**RE: McDonalds – Coors and Hanover
1501 Coors Blvd NW
Grading Plan Engineer's Stamp Date: 2/28/17
Hydrology File: J11D037**

Based upon the information provided in your submittal received 3/9/17, the Grading Plan is approved for Building Permit, Grading Permit, and Paving Permit.

RE: McDonald's 1501 Coors Blvd.
File # J11-D037

GRADING PLAN

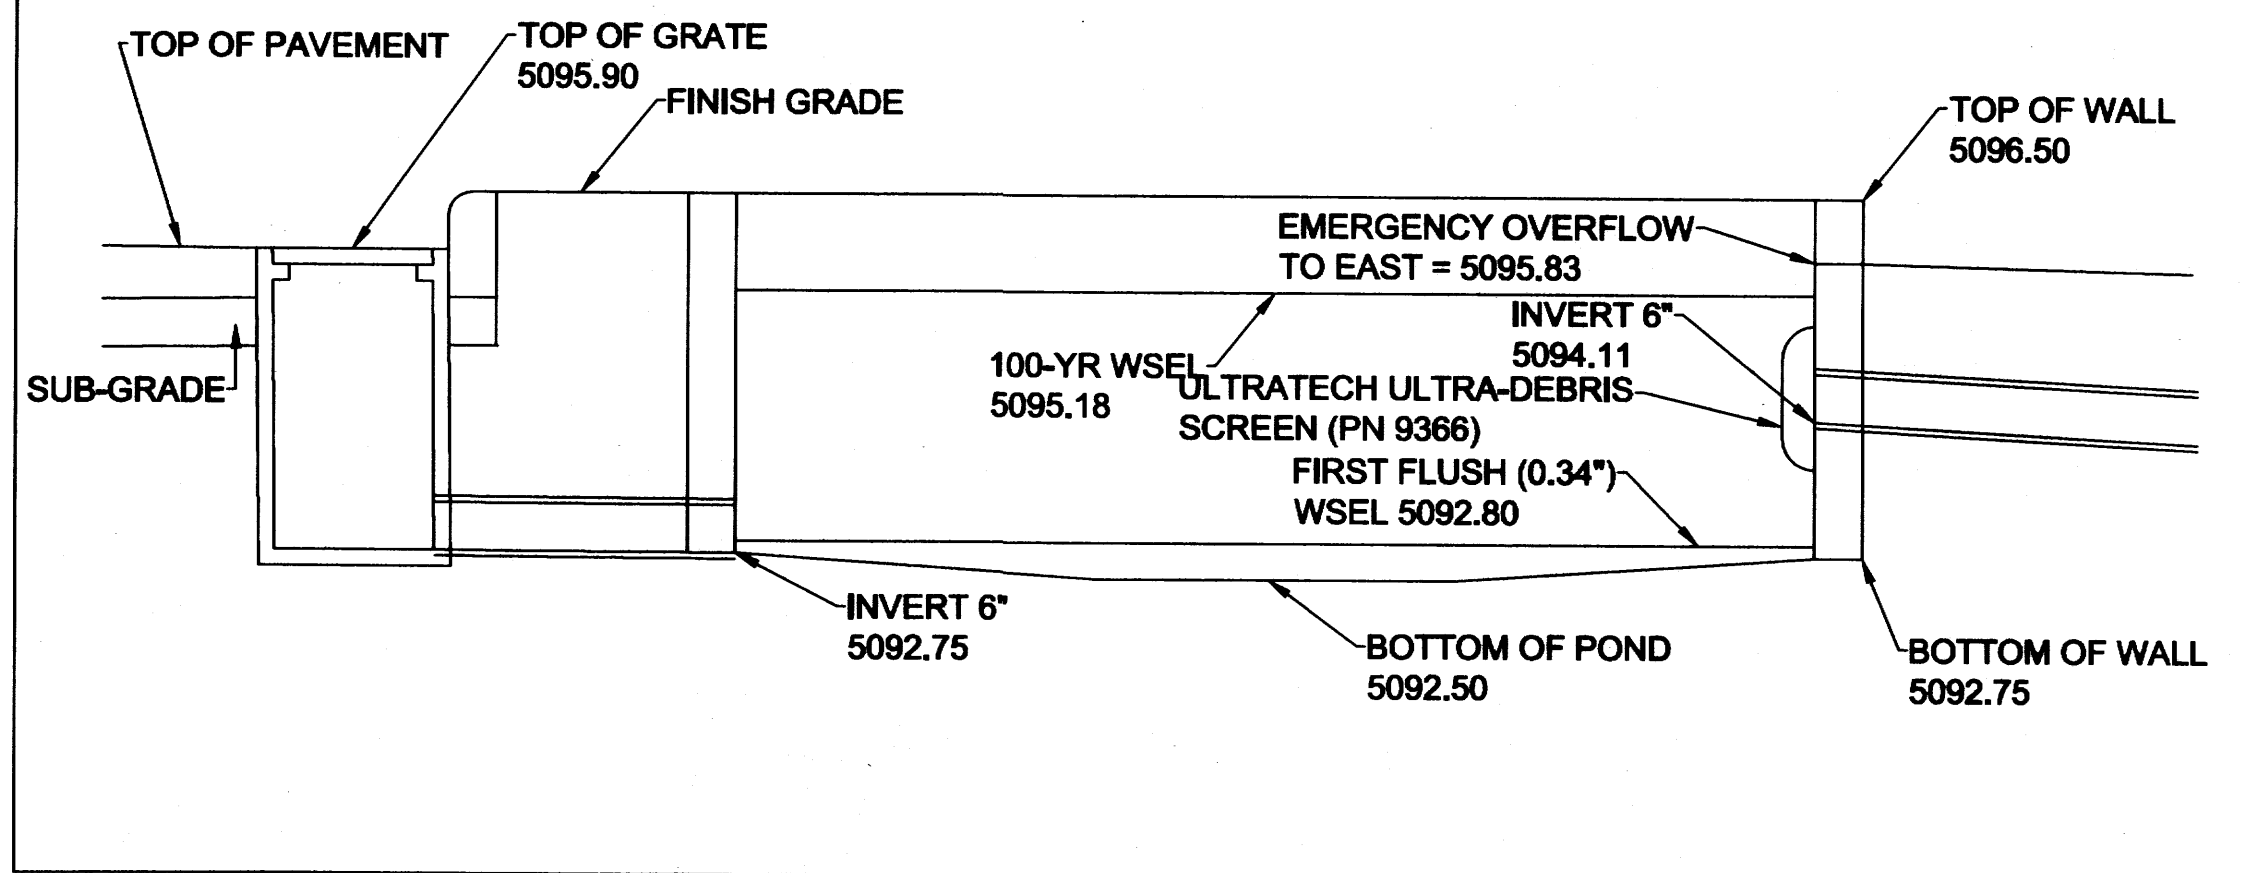
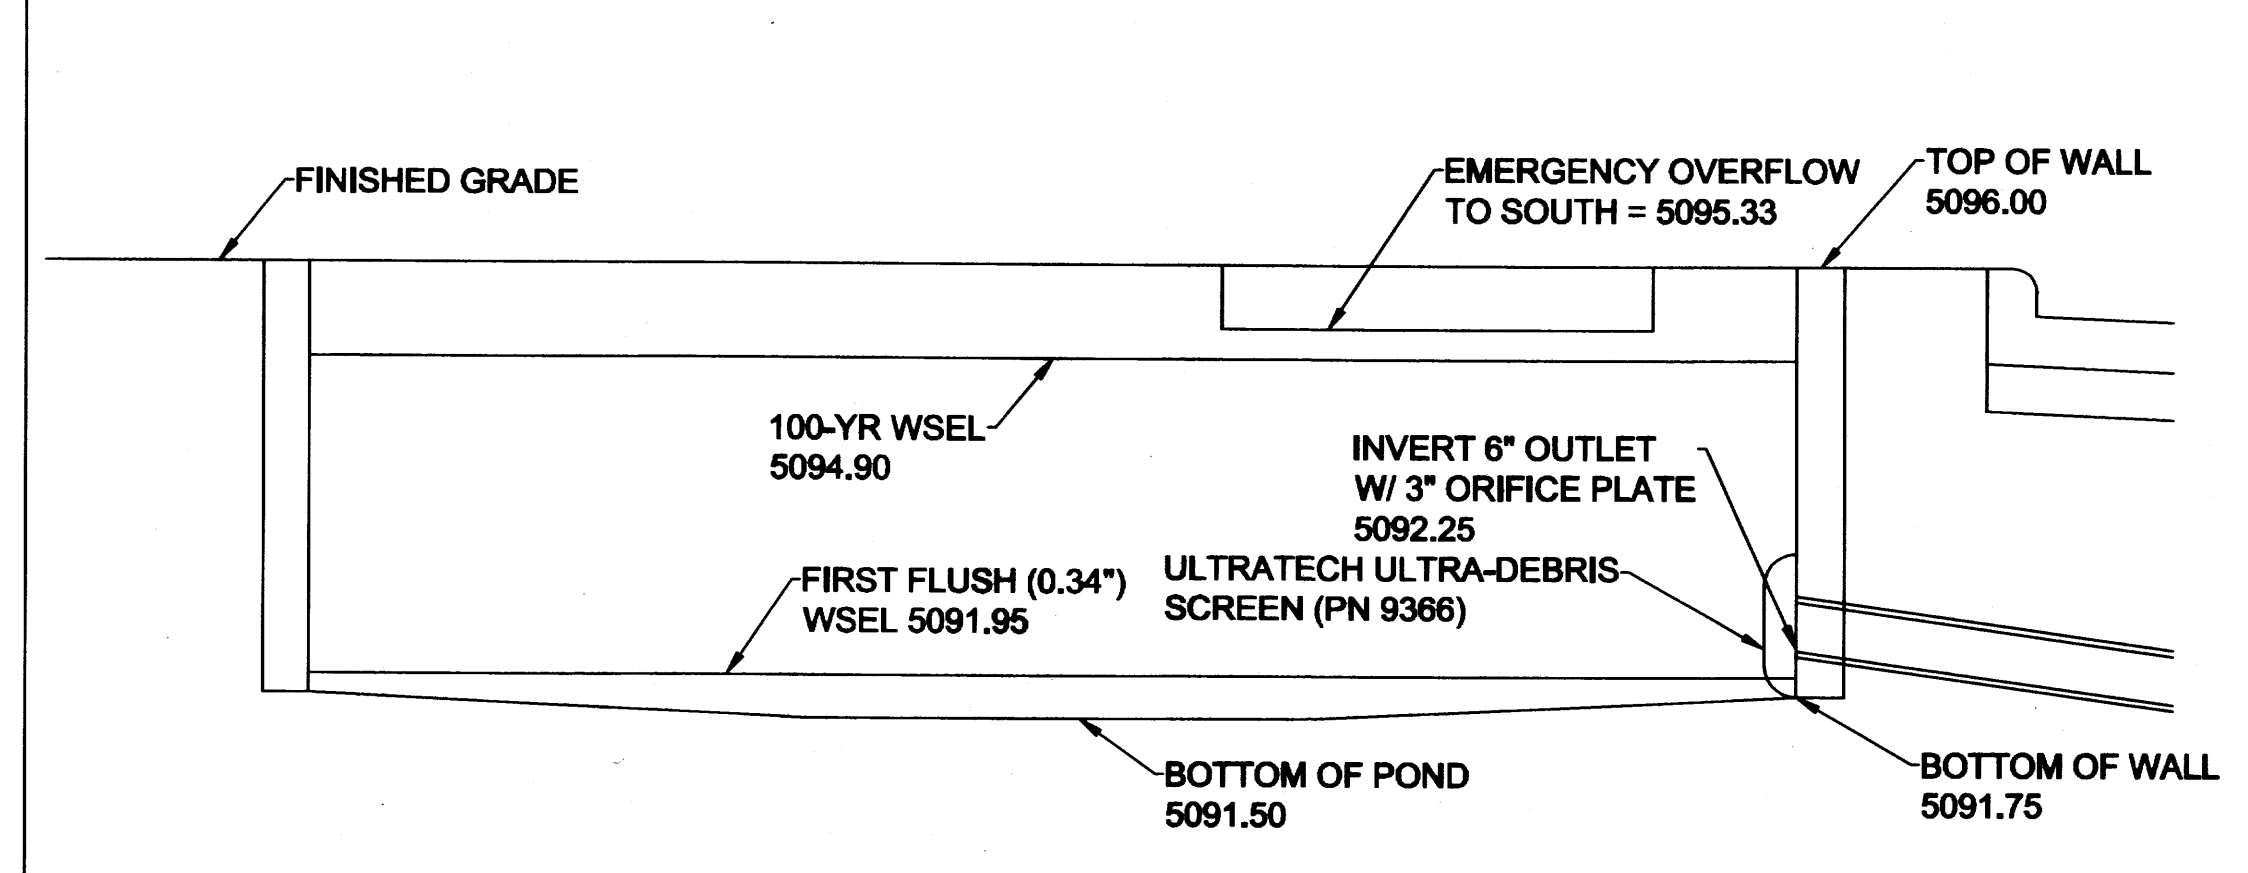
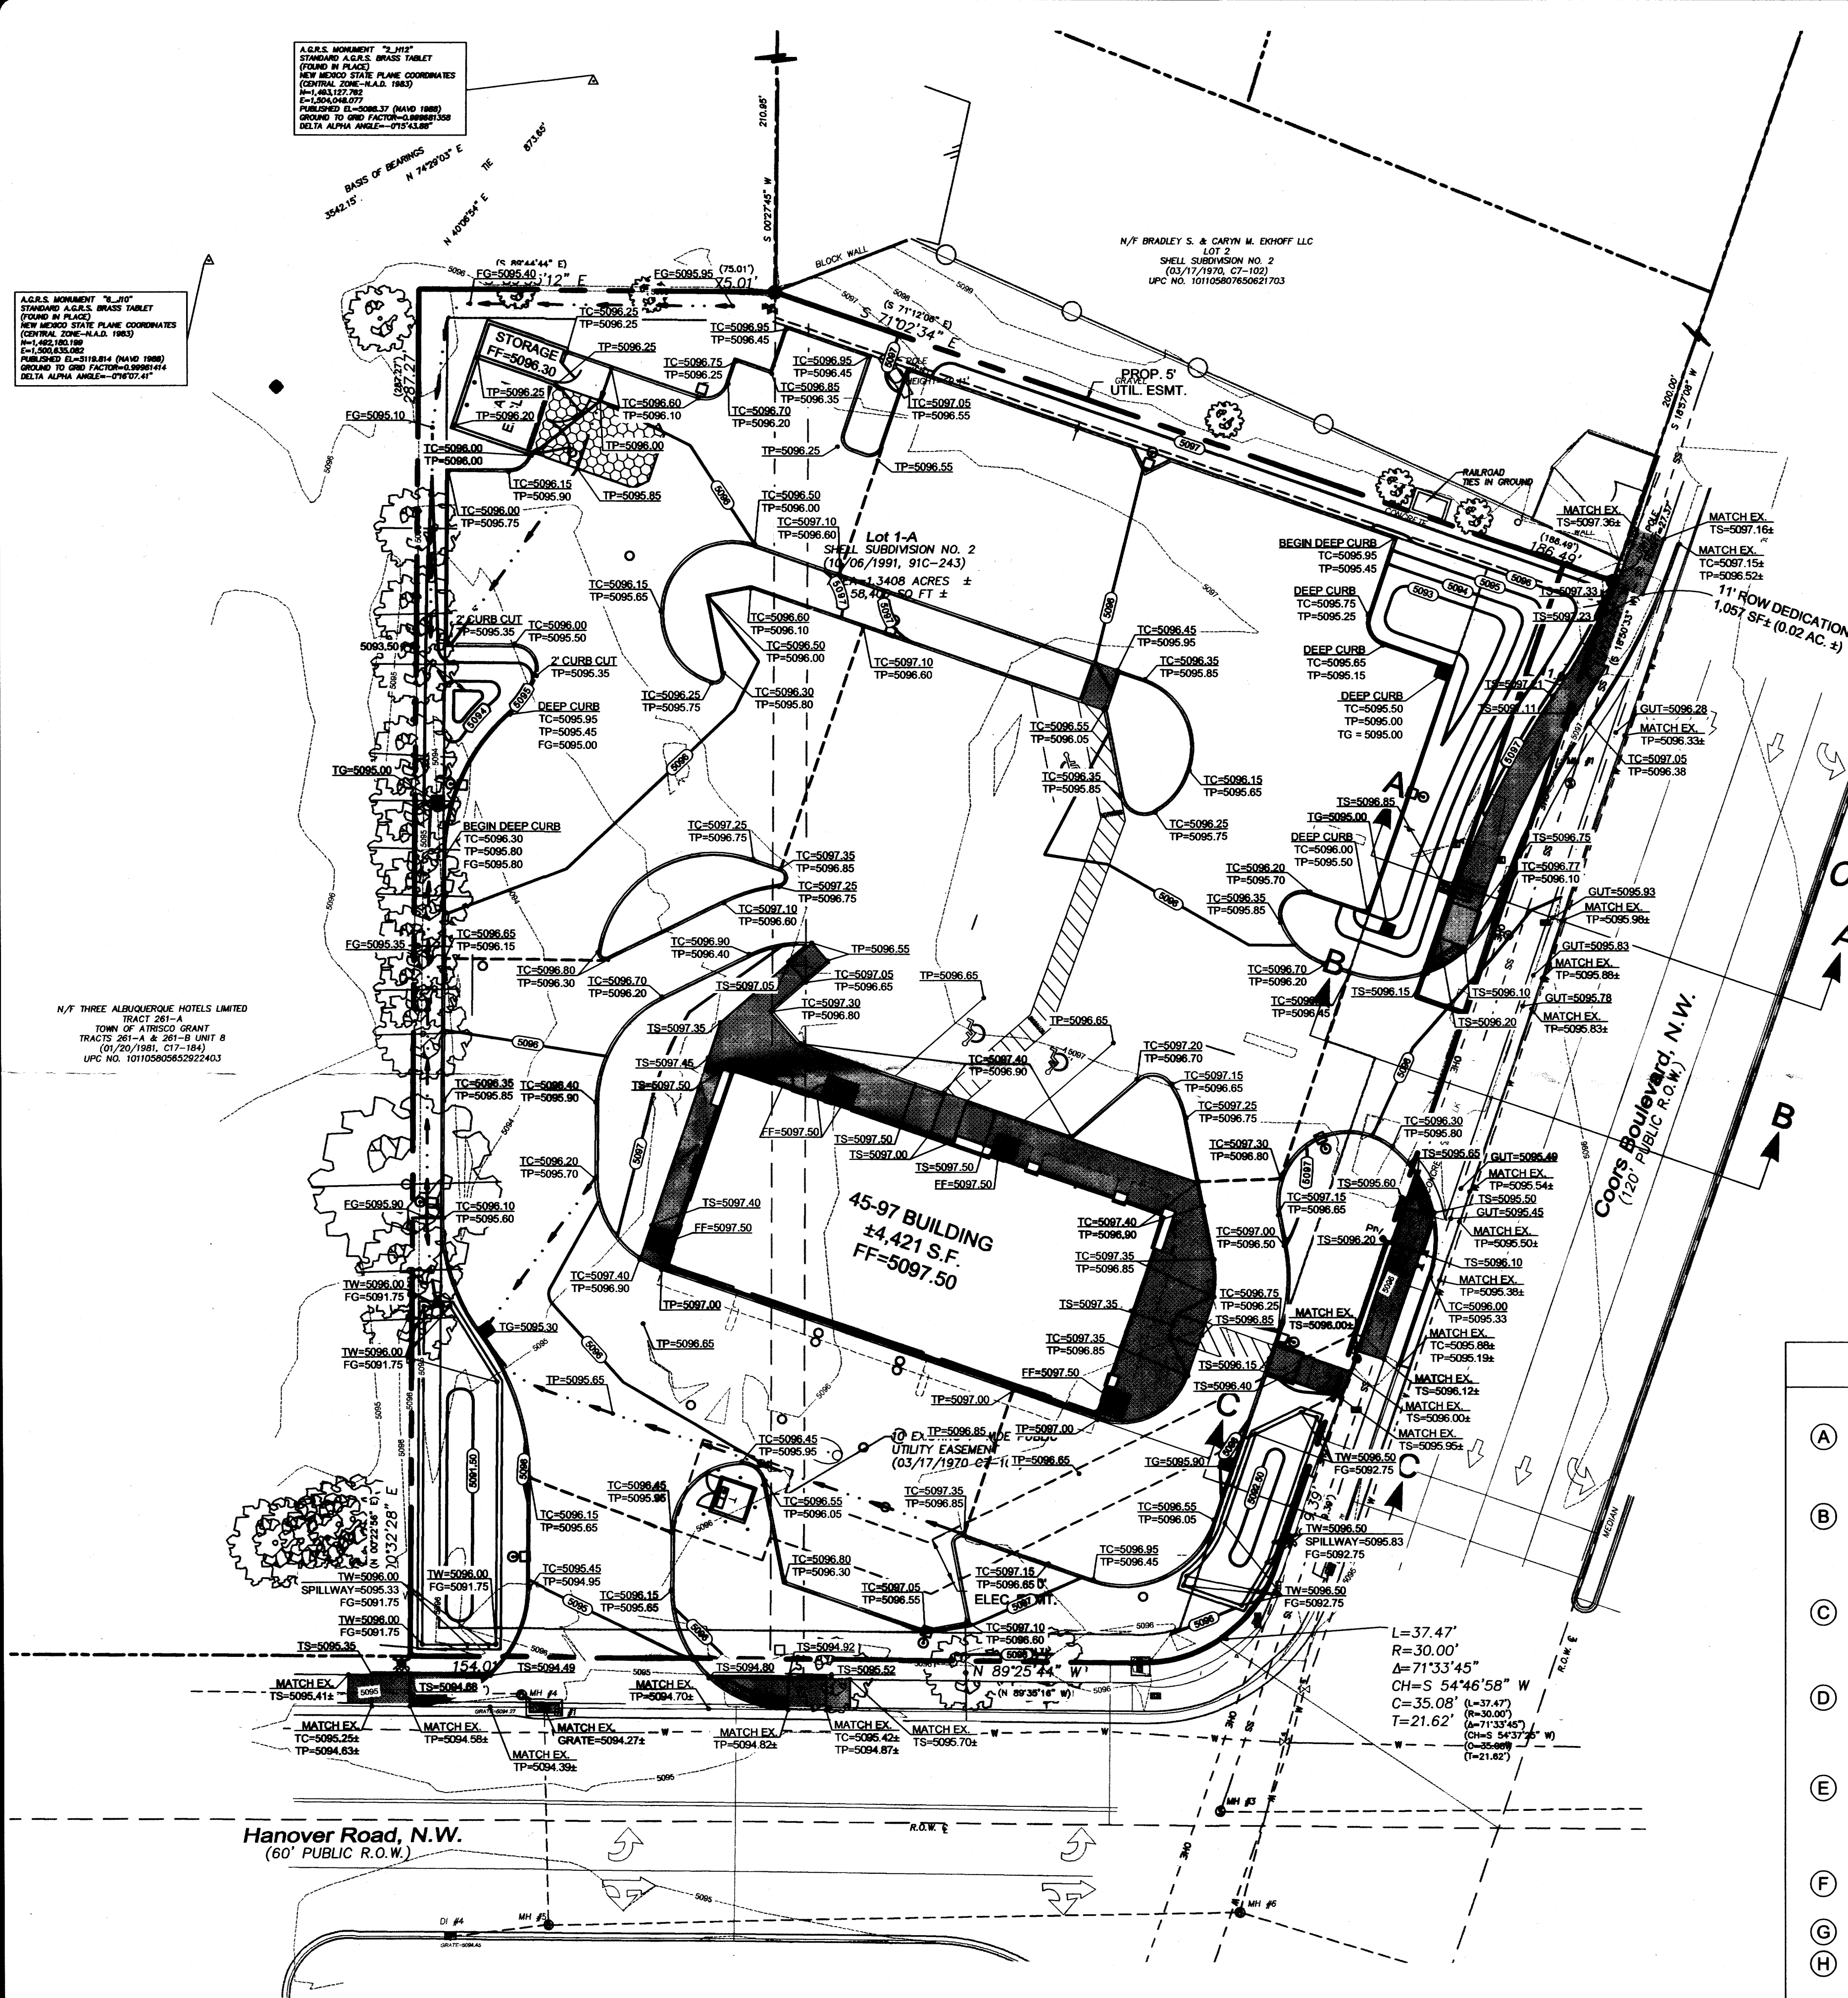
1. Conversion of DI#1 from a Type Single C to a Type Single D requires one of the following as there is no throated inlet less than 150' upstream of this catchment:

- a. A throated drop inlet (Type A or C) may be added within 150' upstream of DI#1.
 - b. DI#1 may be replaced with a Type Double-D inlet. This seems to be the more feasible option.

- We have noted for DI#1 to be replaced with a Type Double D inlet. ✓
2. For connections to City Facilities, storm drain material must be RCP Class 3 or 4, PVC, Ductile Iron Pipe, or HPPP (High Performance Polypropylene Pipe). This applies to STRM-4 tying into MH#4. Additionally, it may be more feasible to tie directly into the back of DI#1.

- ✓ • We have added a note for MH#4 to be lowered to match proposed top of pavement.
- ✓ 4. Ensure the fence around Bio-retention Areas 3 and 4 is at least 42" in height.

- The fence around Bio-retention Areas 3 and 4 will be 4' tall. The detail is shown on Sheet C10.4 Standard Details.
5. Waterblocks, at least 8" high from top of pavement on the drivepad to bottom of gutter along the road, need to be incorporated at the Coors entrance. Correspondence is attached.

- The Top of Pavement elevation shown at the Coors entrance has been modified to be 8" higher than the bottom of gutter along the road.
6. Please coordinate with NMDOT for work within their ROW along Coors Blvd. Provide correspondence showing coordination.

- We have changed the pipe material for STRM-4 to RCP Class 3. ✓
3. Will adjustments be needed to raise or lower MH#4 on Hanover? This is currently on the sidewalk and is proposed to be in the drivepad.

- ✓ • Correspondence with NMDOT is attached.
